Phone: 0300 123 6780  
Email: [developeras@lancashire.gov.uk](mailto:developeras@lancashire.gov.uk)  
Your ref: 3/2025/0133  
Our ref: 3/2025/0133/HDC/KW  
Date: 19 June 2025

**Location:** Loft Shay Farm Clitheroe Road Ribchester PR3 2YQ  
**Proposal:** Regularisation of change of use of land to form extended residential curtilage and installation of Air Source Heat Pump. Proposed detached garage to include solar panels and living accommodation above. Enlargement of existing first floor side facing window to main dwelling.  
**Grid Ref:** 364067 438228

PROJECT
Proposed Detached Garage & Associated alterations
SHEET
Proposed Site Plan Revision D

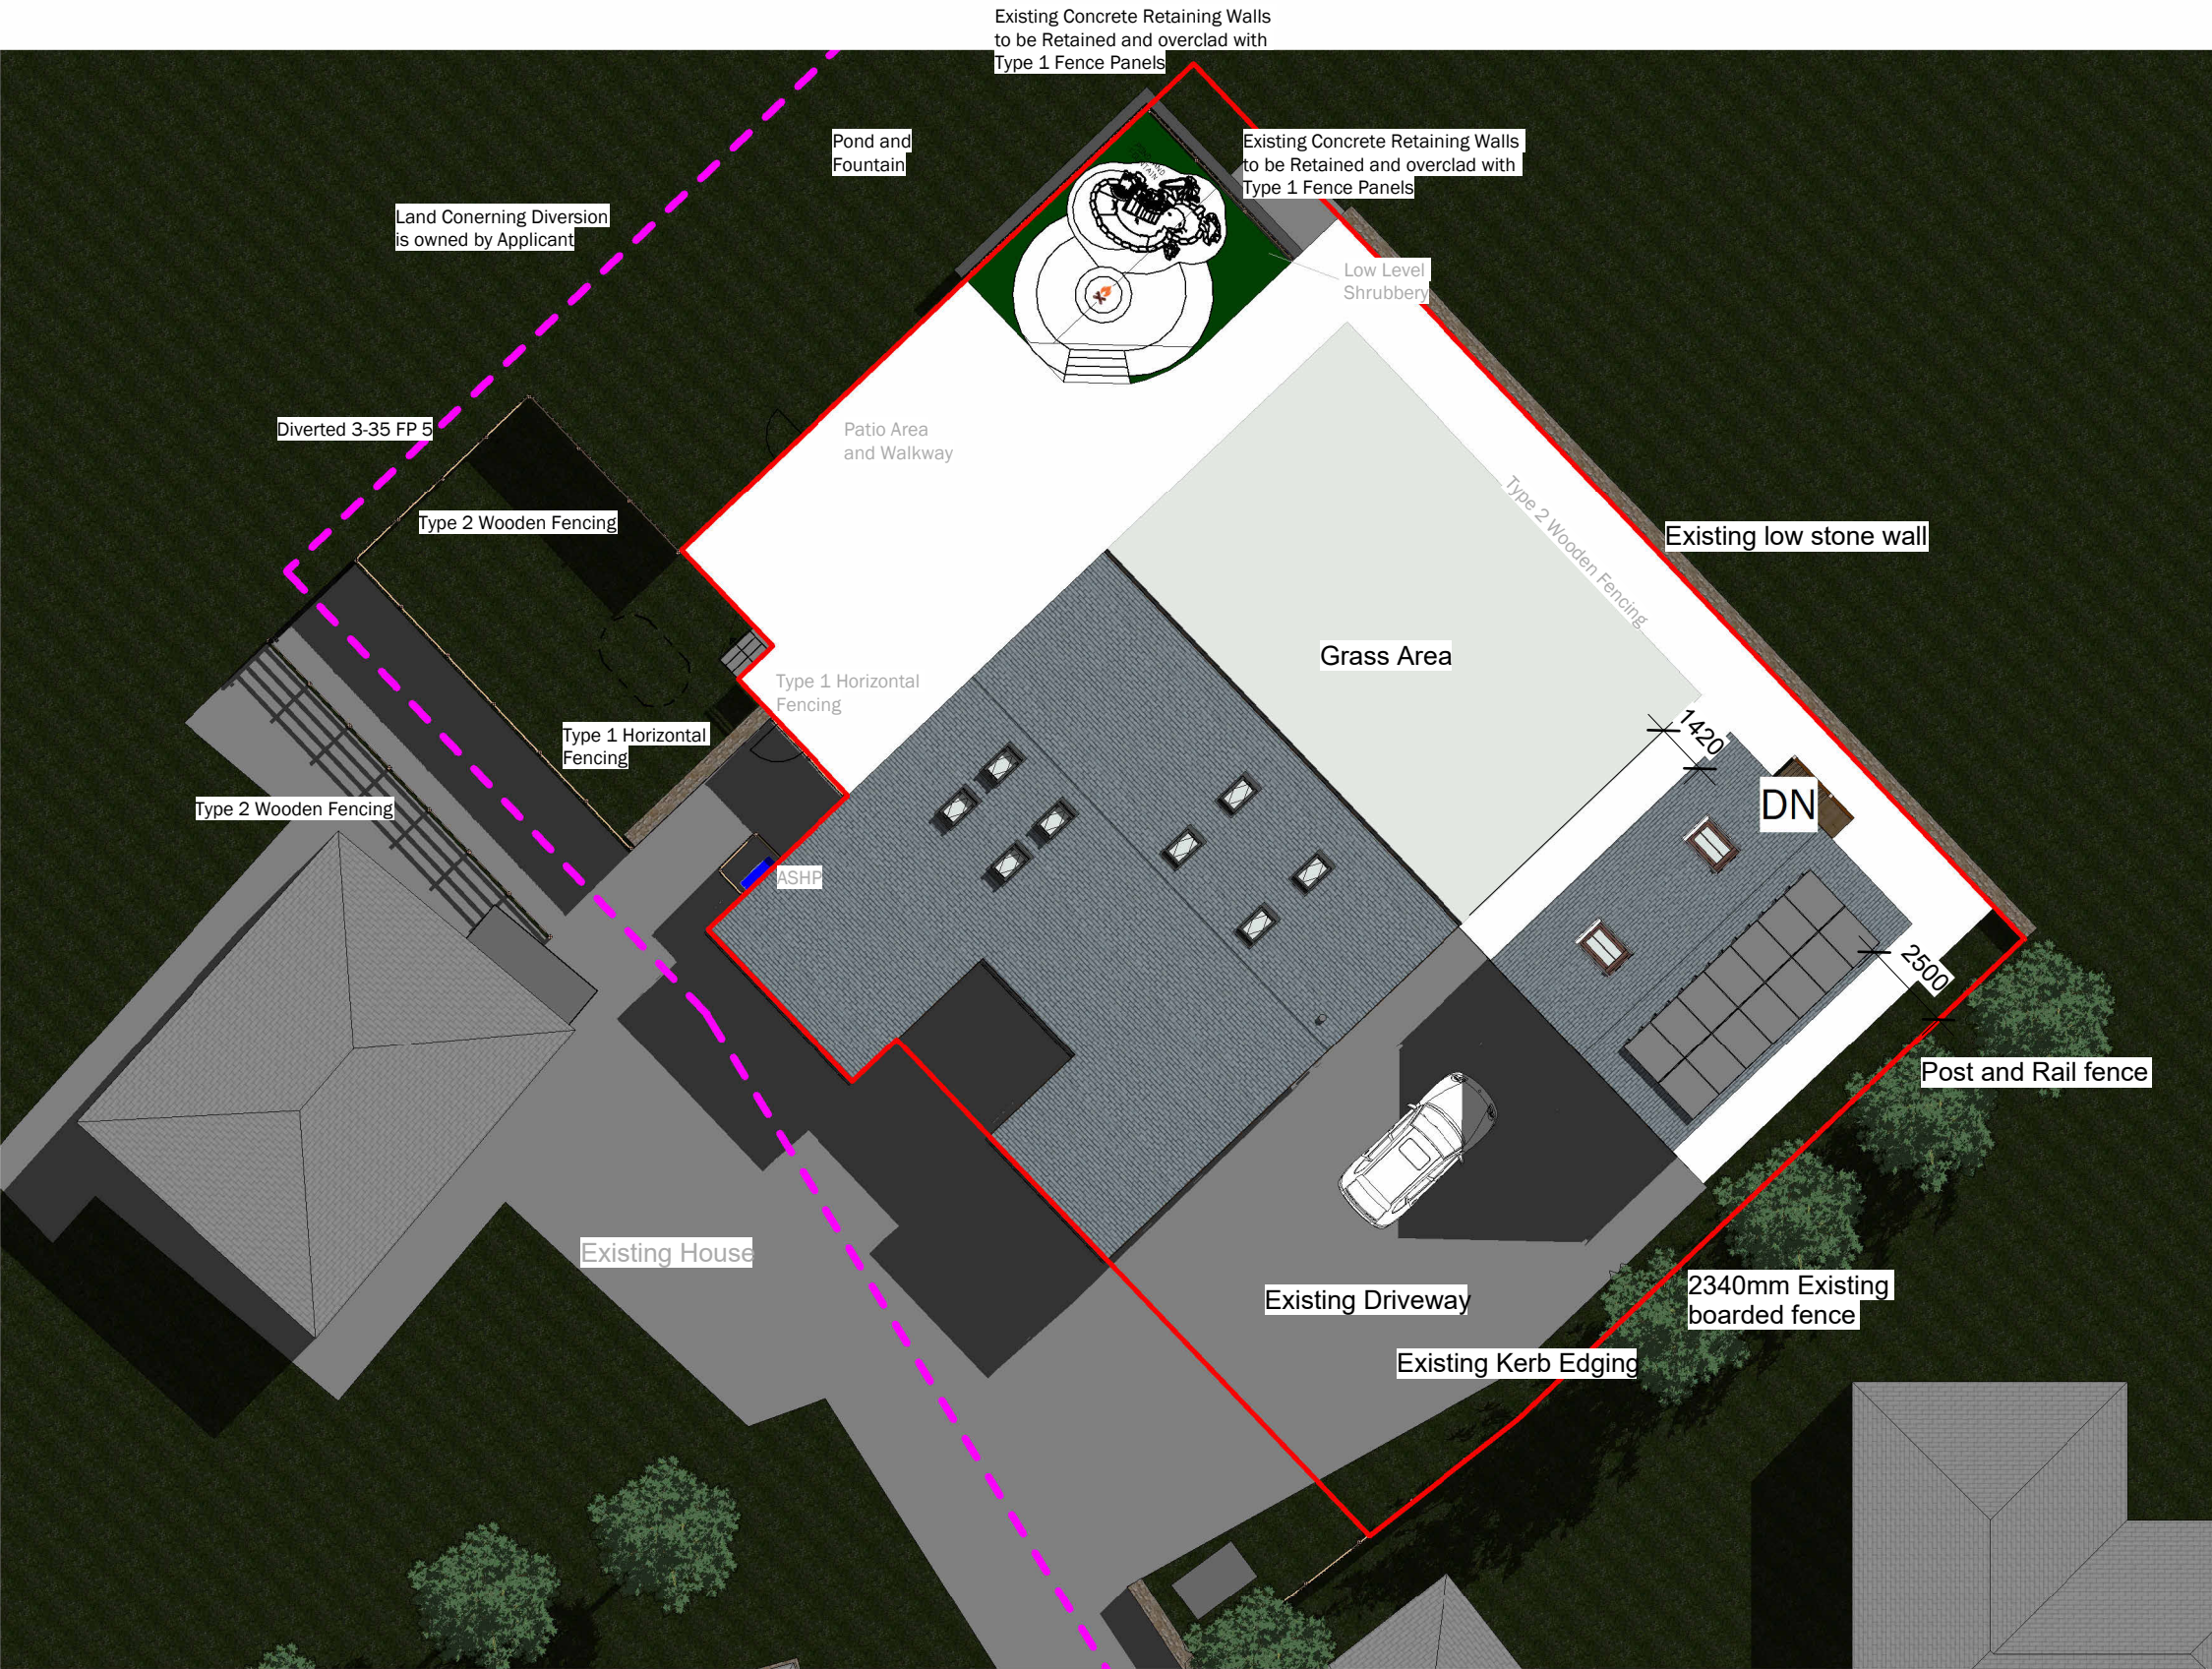
Please note that there are Public Rights of Way's FP0302069 through the application site. The applicant has included a diversion for the Public Right of Way in order to create a garage on the existing footway line. The granting of planning permission does not constitute the diversion of a Definitive Right of Way. The applicant should be advised to contact Lancashire County Council's Public Rights of Way section by email on [PROW@lancashire.gov.uk](mailto:PROW@lancashire.gov.uk), quoting the location, district and planning application number, to discuss their proposal before any development works begin.

A2.2.1

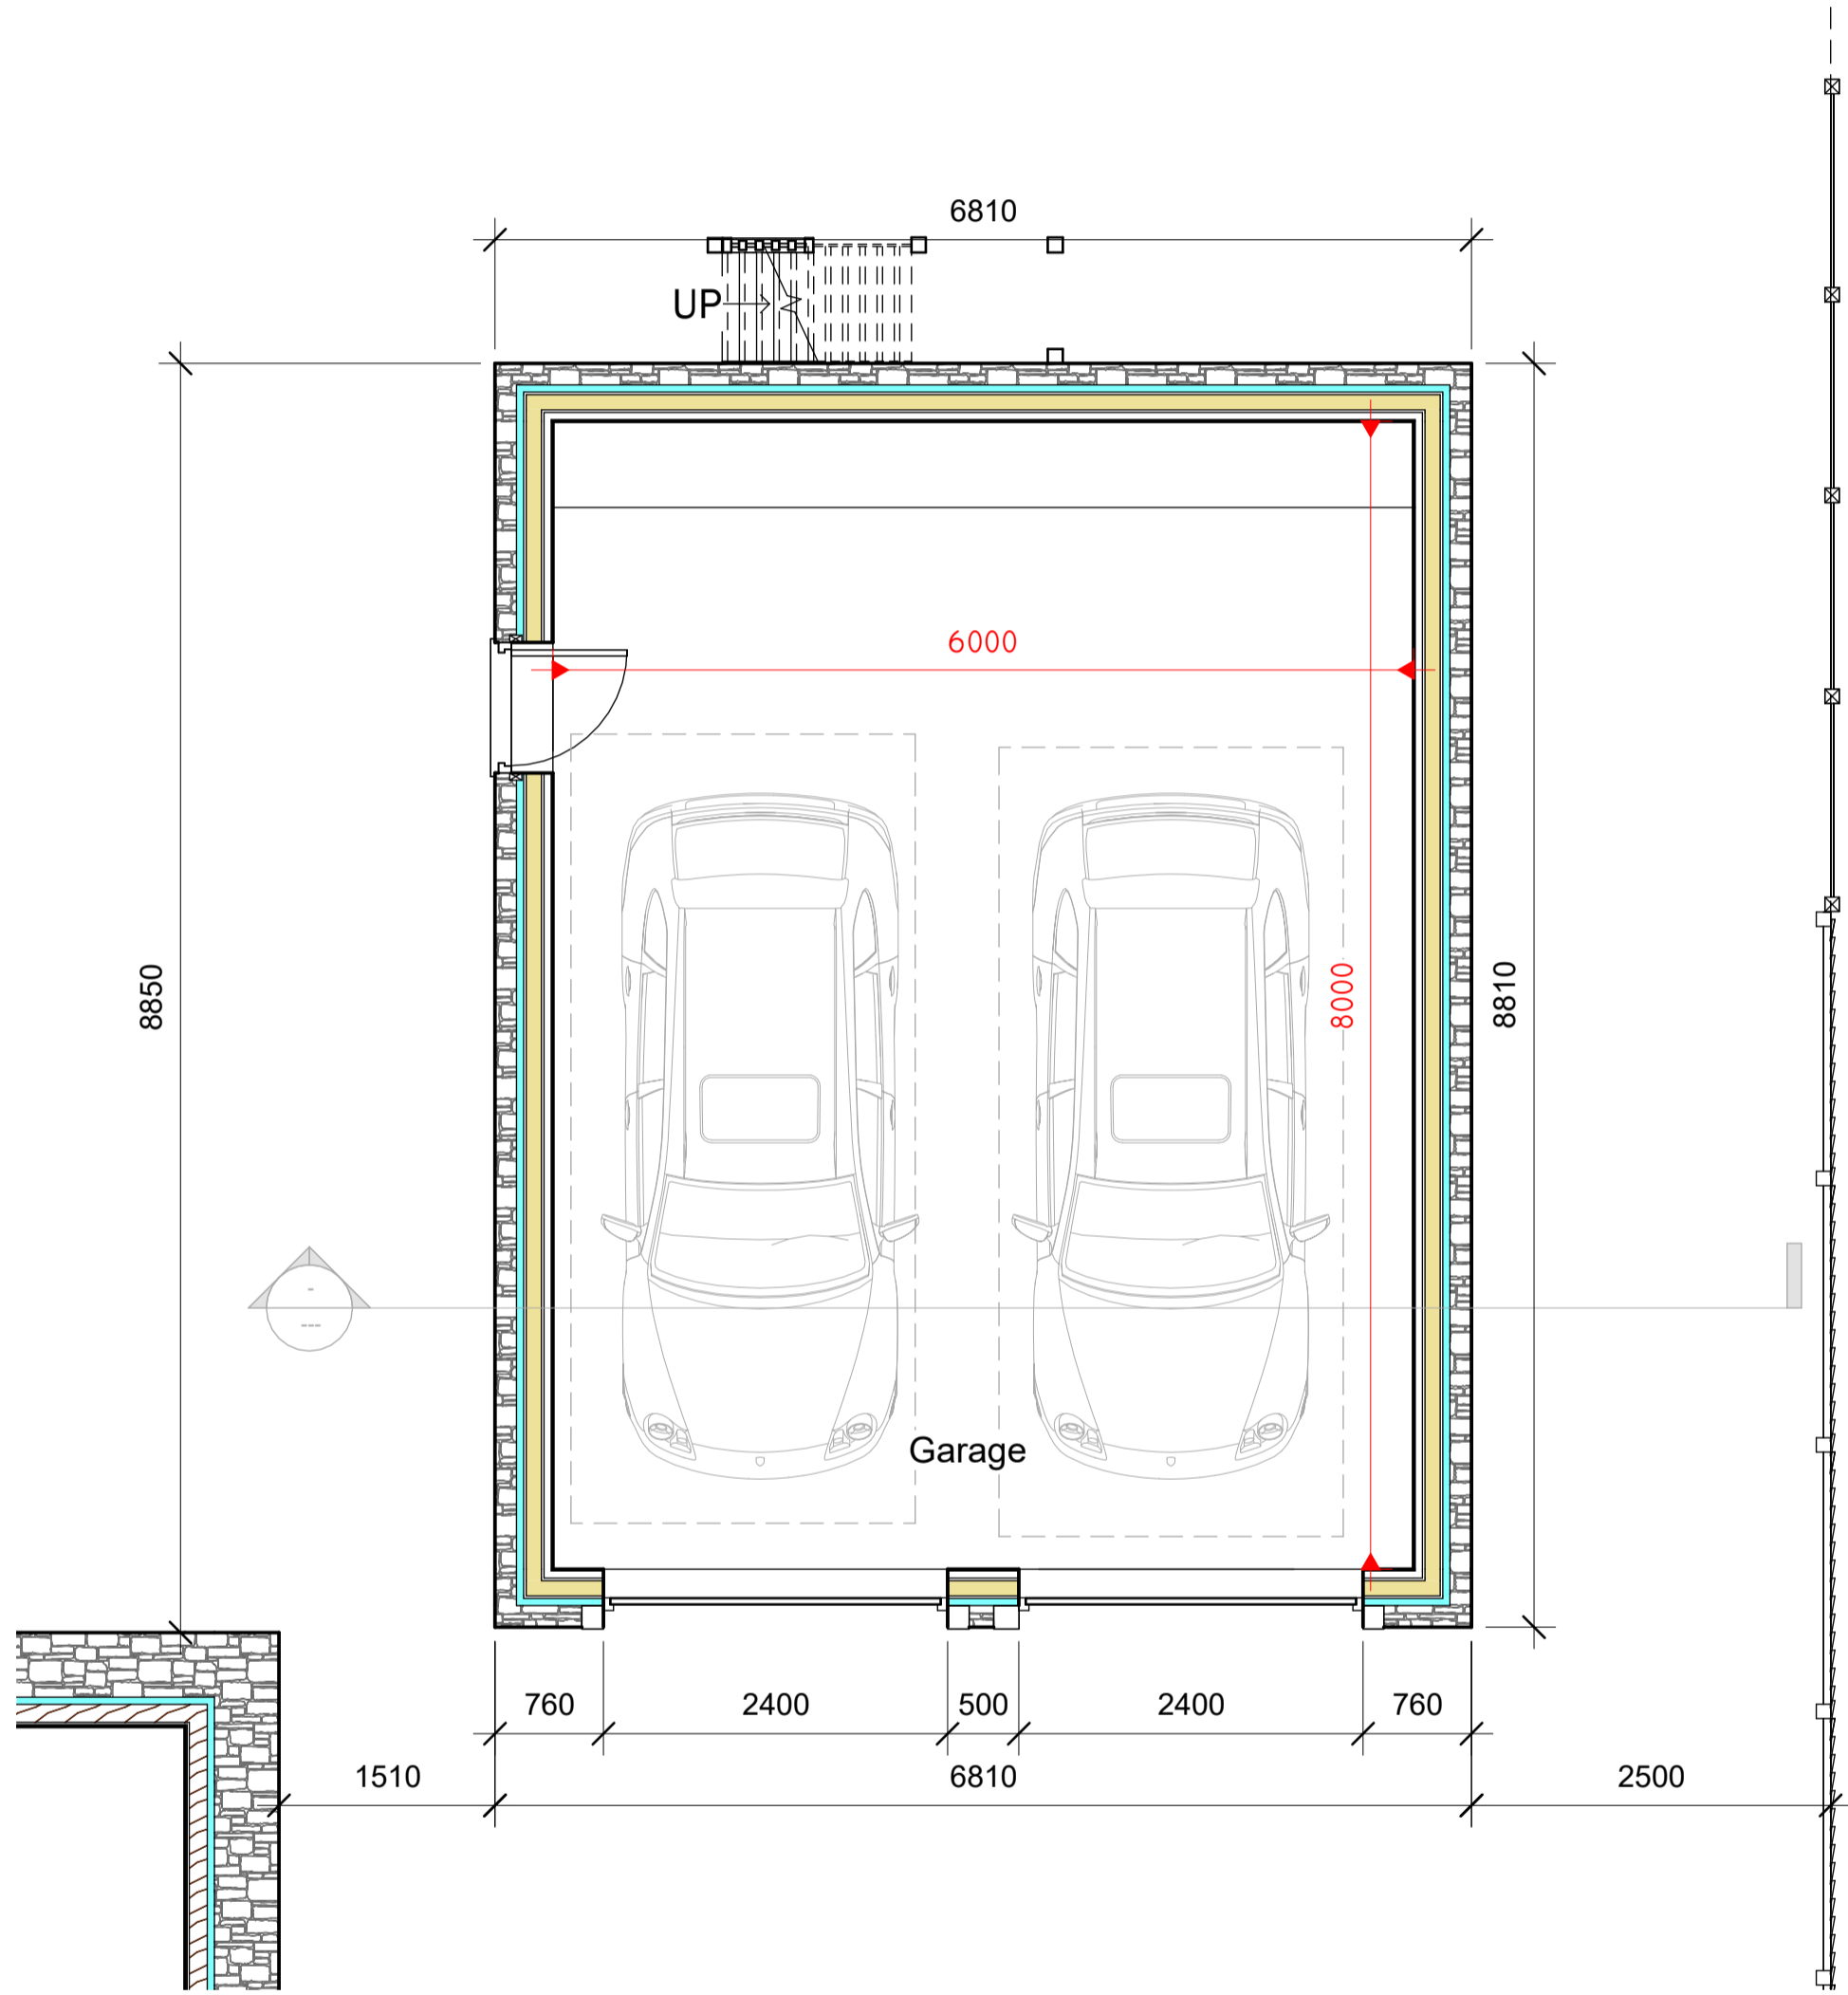
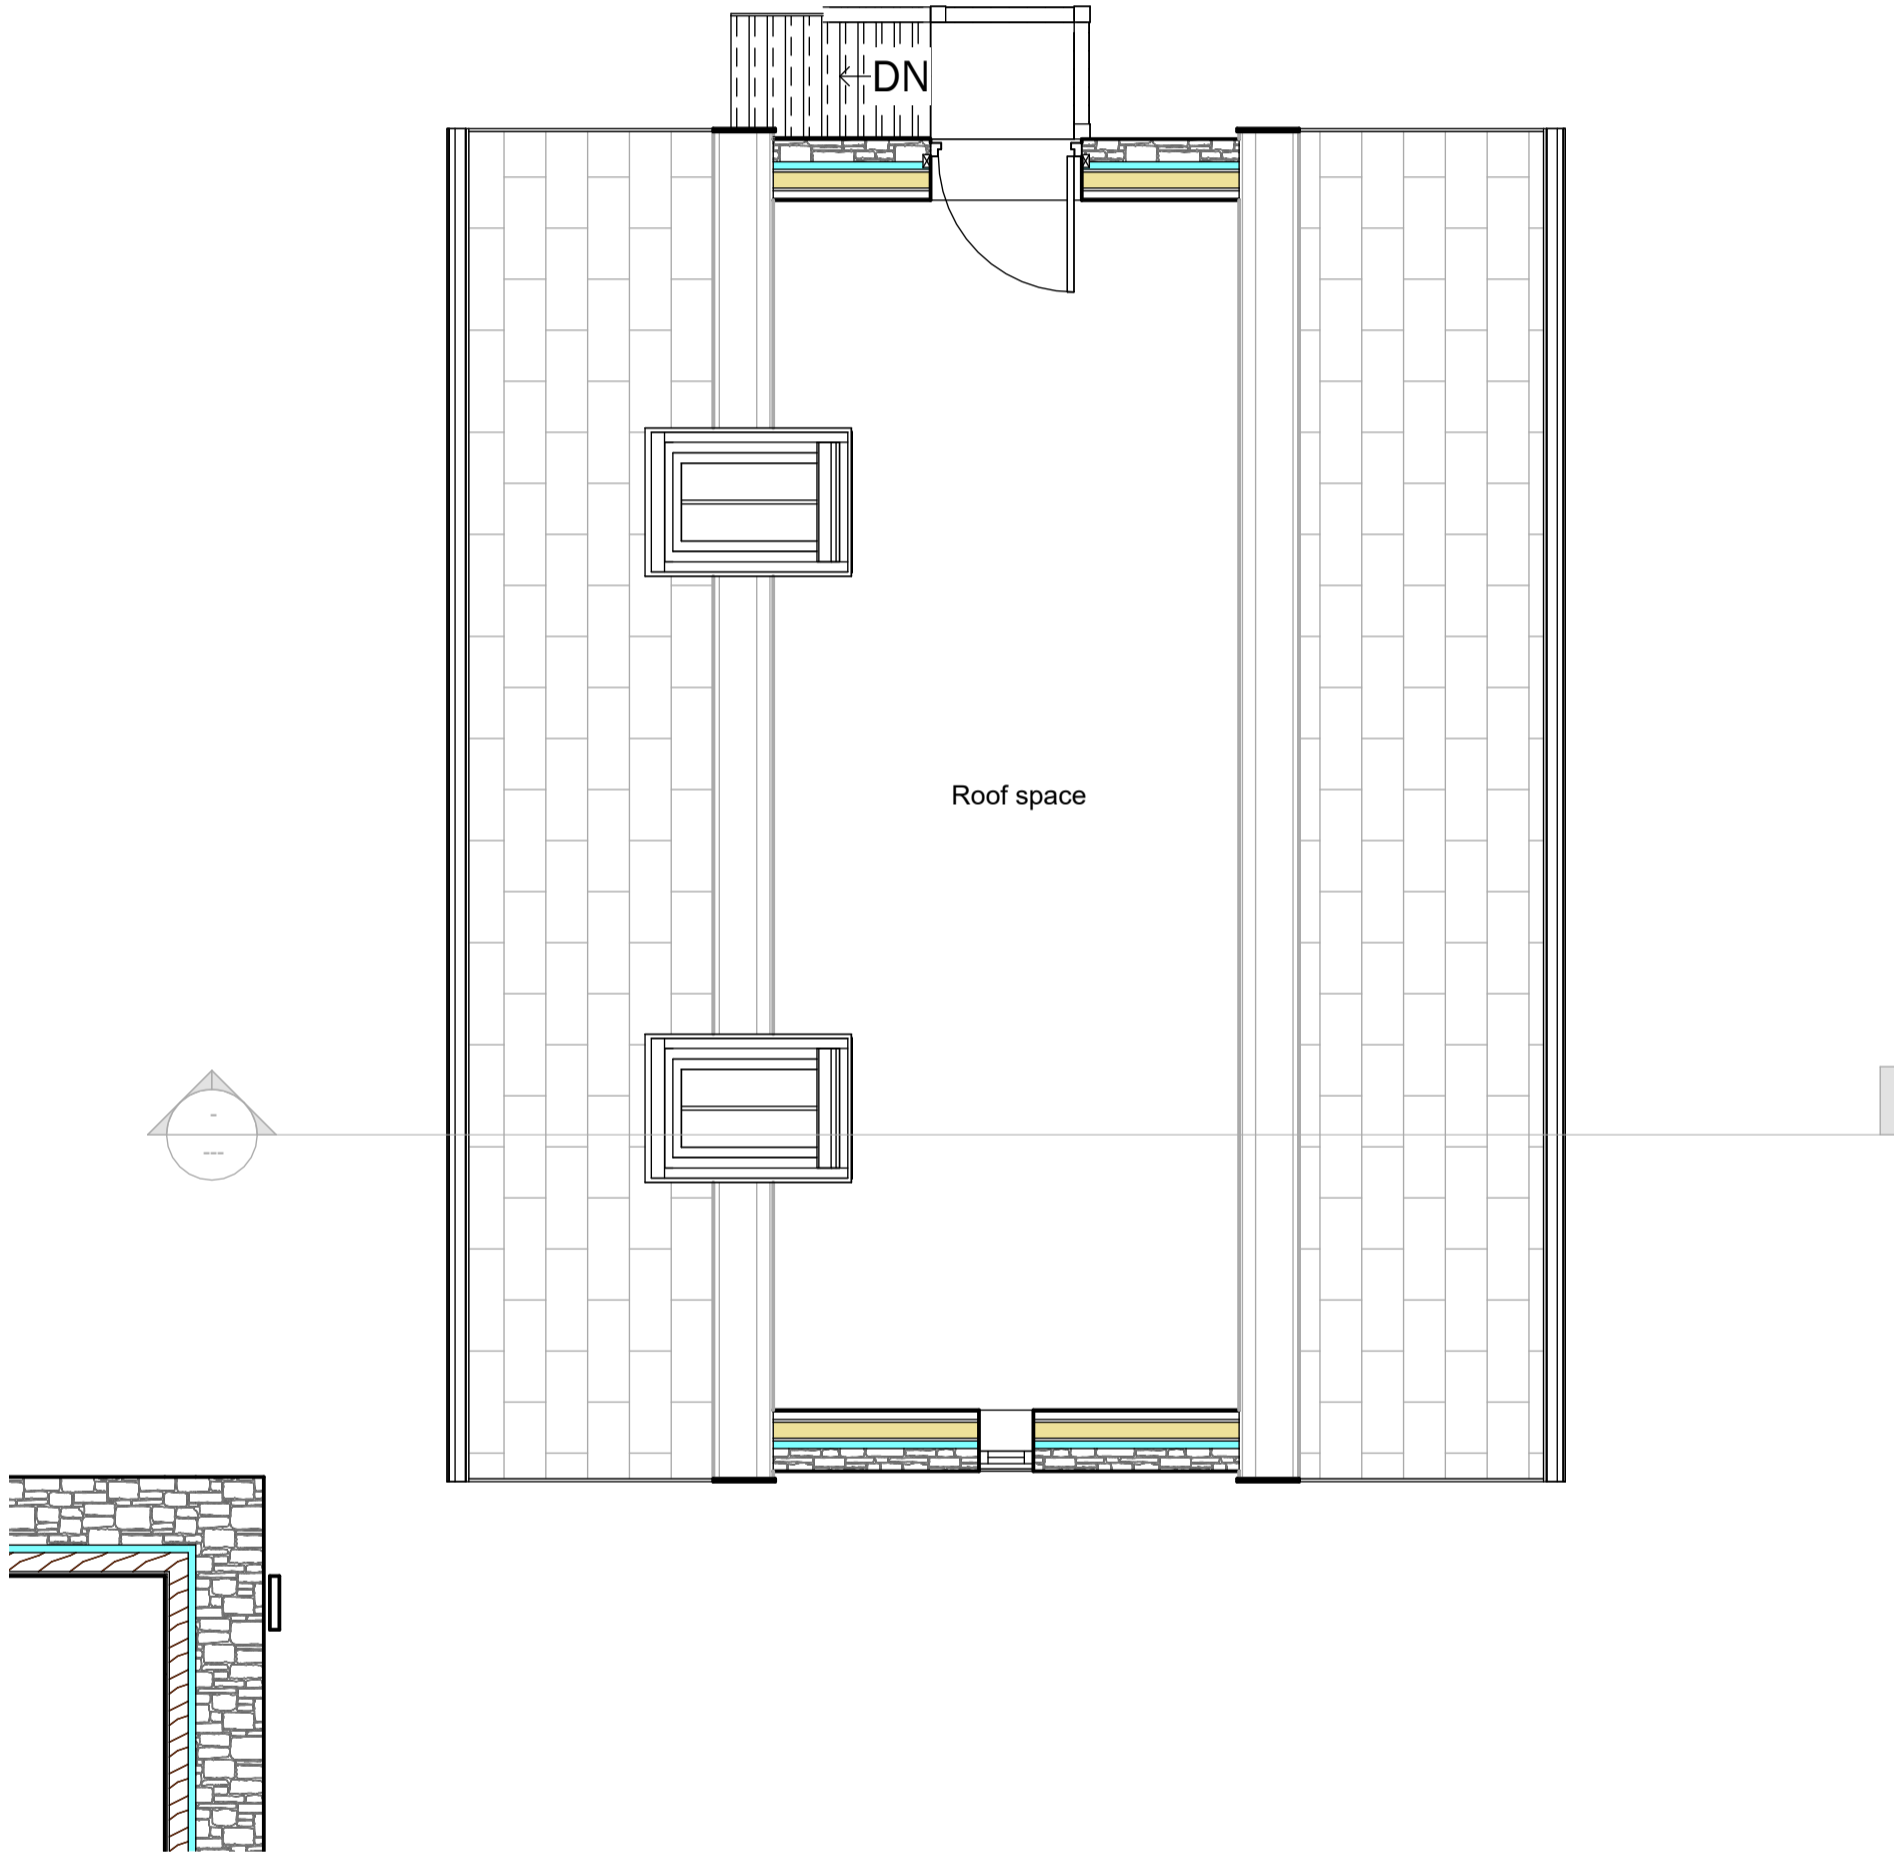
The recommended minimum internal dimensions for a single garage size is 6m in length and 3m wide. The recommended distance of 6m is based on the length of a large family car (Ford Mondeo Estate 4.58m long), clearance at the rear of the car (200mm), overhang of the garage door (600mm) and room to stand in front of the car and open/close the garage door (600mm). The LHA has reviewed the Proposed Plans Revision C, drawing A2.2.1 and note that the garage has been designed to an acceptable internal size to provide parking.
